WEST SUSSEX COUNTY COUNCIL CONSULTATION

TO:	Arun District Council FAO:Ms M Tomalova
FROM:	WSCC - Highways Authority
DATE:	25 May 2022
LOCATION:	Greybarn Church Lane Bognor Regis PO21 4NX
SUBJECT:	P/60/22/PL Replace existing conservatory with front porch, single storey rear extension and dormer windows. Extension of existing garage and part conversion to tourist accommodation. This application may affect the setting of a Listed Building.
DATE OF SITE VISIT:	n/a
RECOMMENDATION:	More Information
S106 CONTRIBUTION TOTAL:	n/a

SITE PLAN
1:500@A3

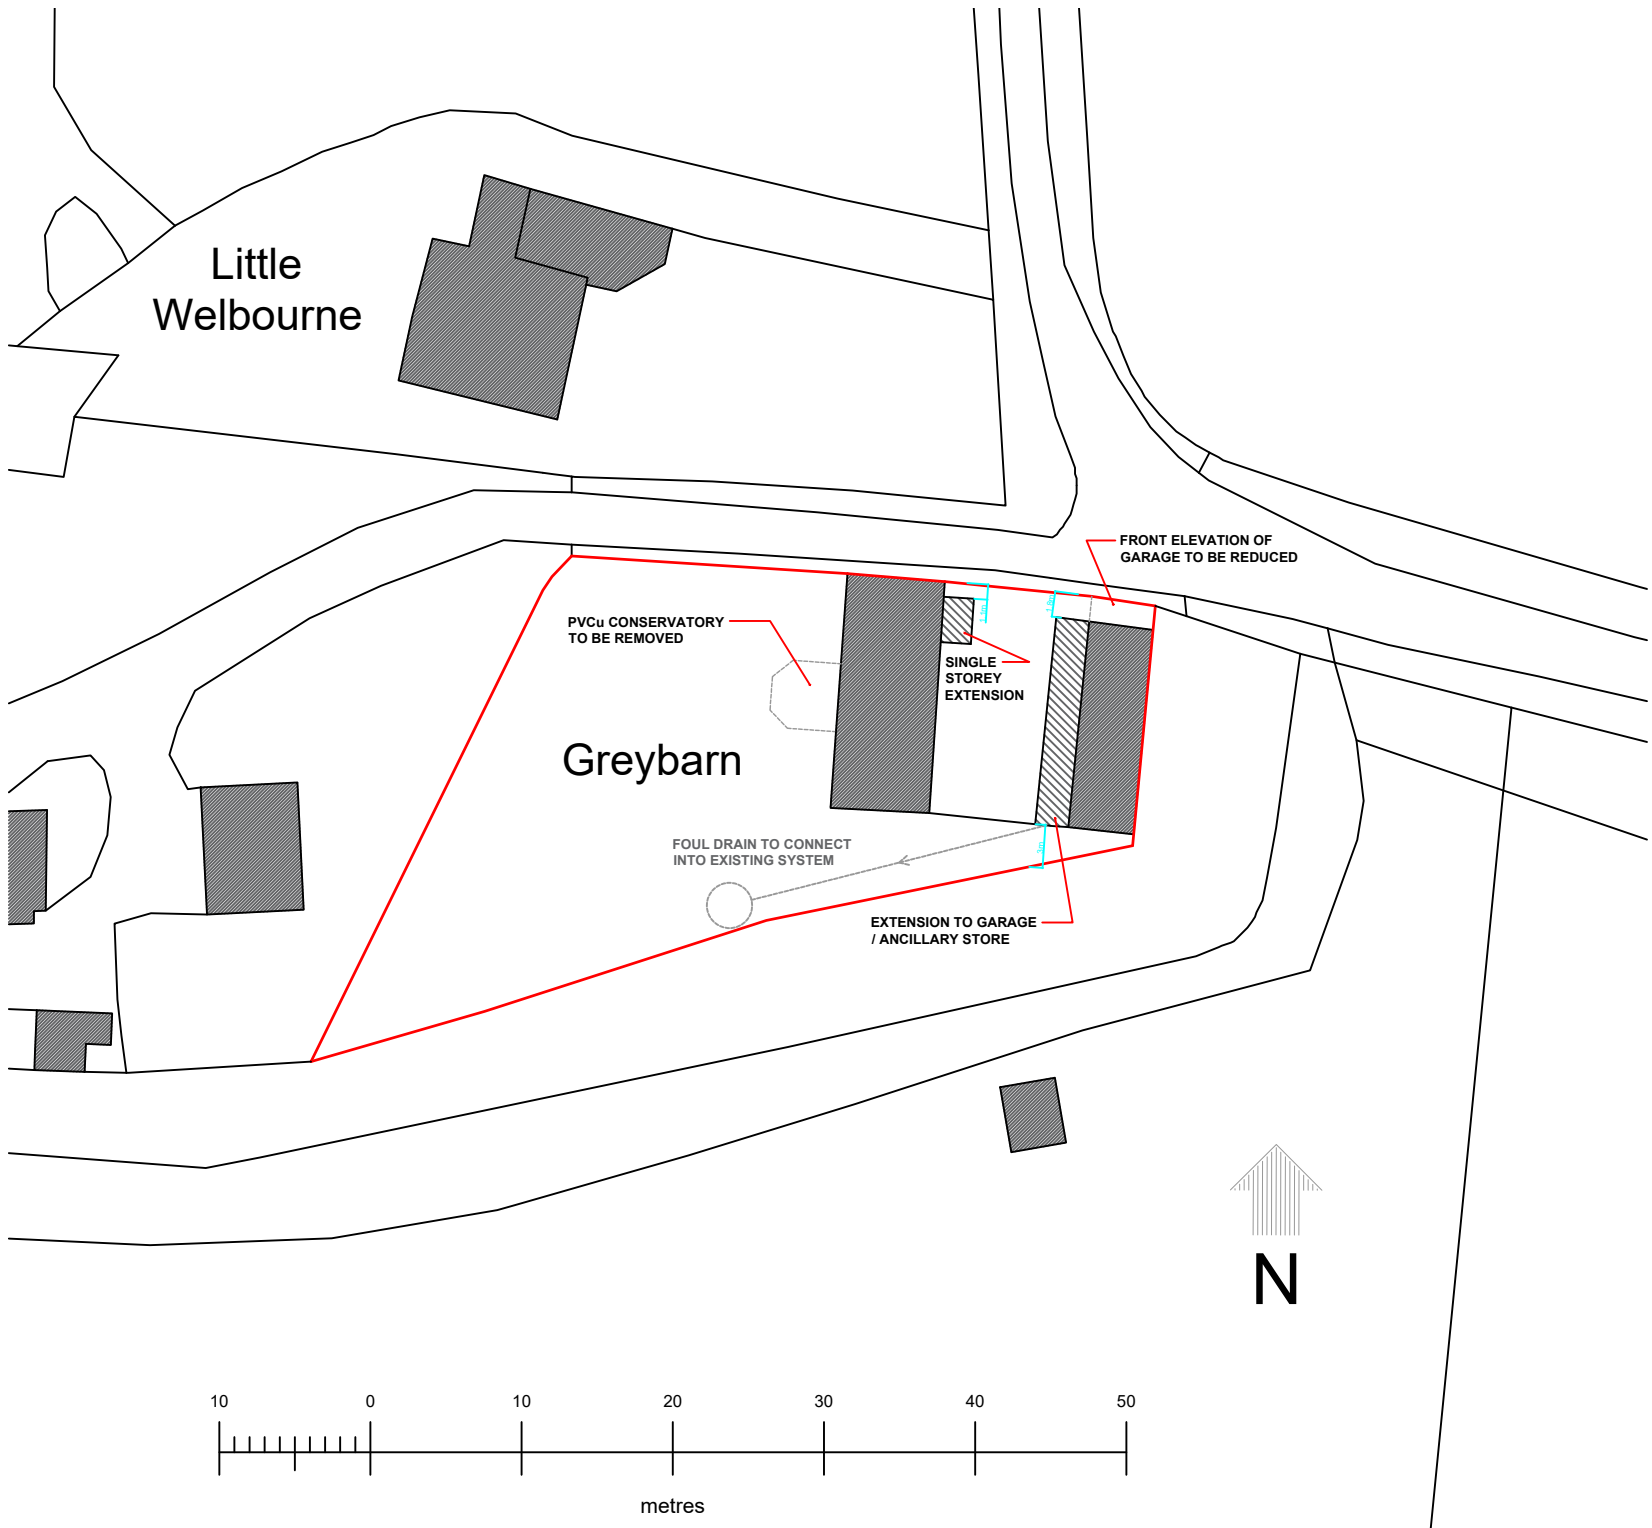
The proposed plan demonstrate the ancillary tourist accommodation containing double garage. At present the existing garage seems of sufficient size to accommodate one vehicle. As a result of the proposal, two parking spaces are to be situated within the proposed garage and one within the curtilage area. This space has not been demonstrated.

The applicant is requested to provide additional details clarifying if the existing wall is to be removed to accommodate the proposed parking provision? Please provide a revised plan demonstrating all parking spaces. If the existing access is to be widened, as a result of the proposal, this would need to be constructed under a WSCC Highway licence to a specification agreed with Highways Engineer.
